From: Tim Townsend [REDACTED]
Sent: 07 April 2022 13:08
To: Michael Eastham <Michael.Eastham@arun.gov.uk>
Cc: SU Local Development [REDACTED]
Subject: RE: Response To Application Number LU/370/21/PL at Phase 3 Hampton Park Toddington Lane Littlehampton BN17 7PL

Please find attached a copy of the revised Tree Replacement Plan for LU/370/21/PL.

- Drawing No. A088461 LA300 Rev. X - Parcel A2 & B6 - Landscape Layout.
- Drawing No. A088461 LA301 Rev. X - Parcel A2 & B6 - Proposed Planting: 1 of 2.
- Drawing No. A088461 LA302 Rev. X - Parcel A2 & B6 - Proposed Planting 2 of 2.
- Drawing No. A088461 LA303 Rev. X - Parcel A2 & B6 - LEAP Design.

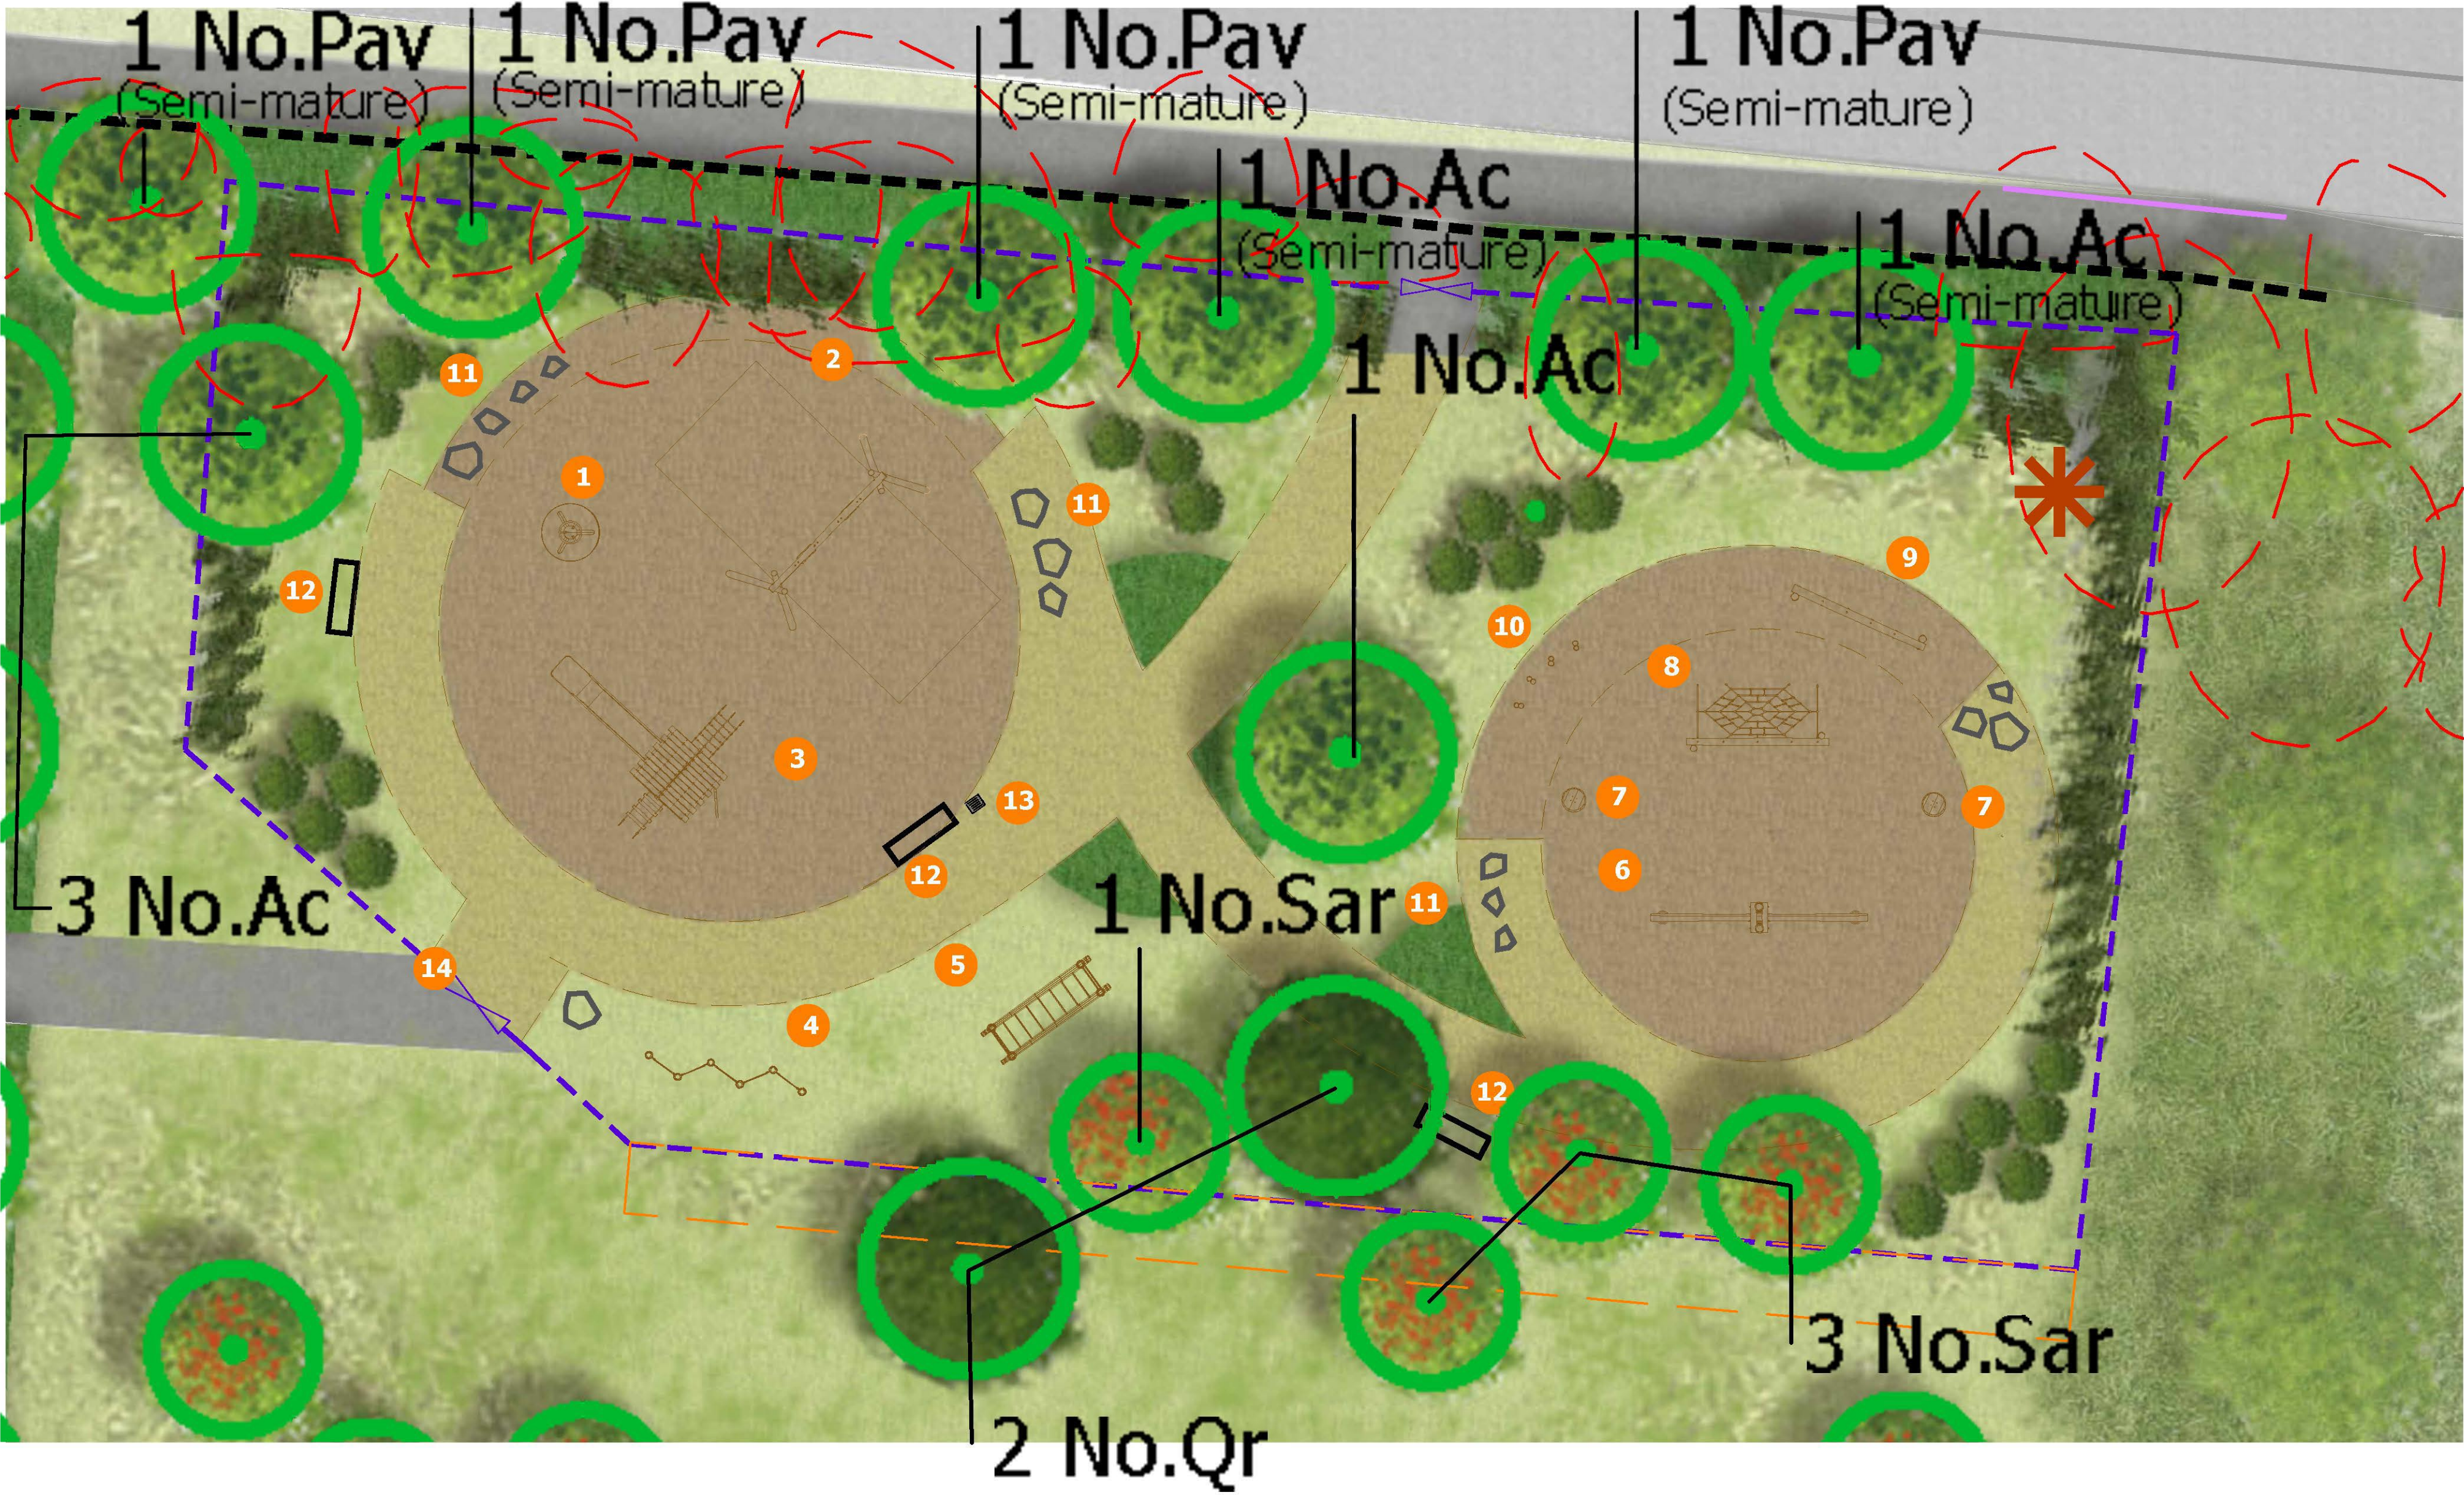
In my haste replying to you yesterday, I missed one detail on the latest plan and that is the proposed 'log pile' adjacent to the viaduct/By-Pass overbridge. Please can you delete this from the plan as we would not, for safety

reasons, want such a feature adjacent to the viaduct as it could potentially prove to be a fire hazard to the structure and could also pose an obstruction to maintenance vehicles.

No highway objection raised now that the log pile previously shown adjacent to the by-pass overbridge has now been removed from the latest plan.

Further to your email, please find attached the amended plans for **LU/370/21/PL** removing the log pile by the Bypass.
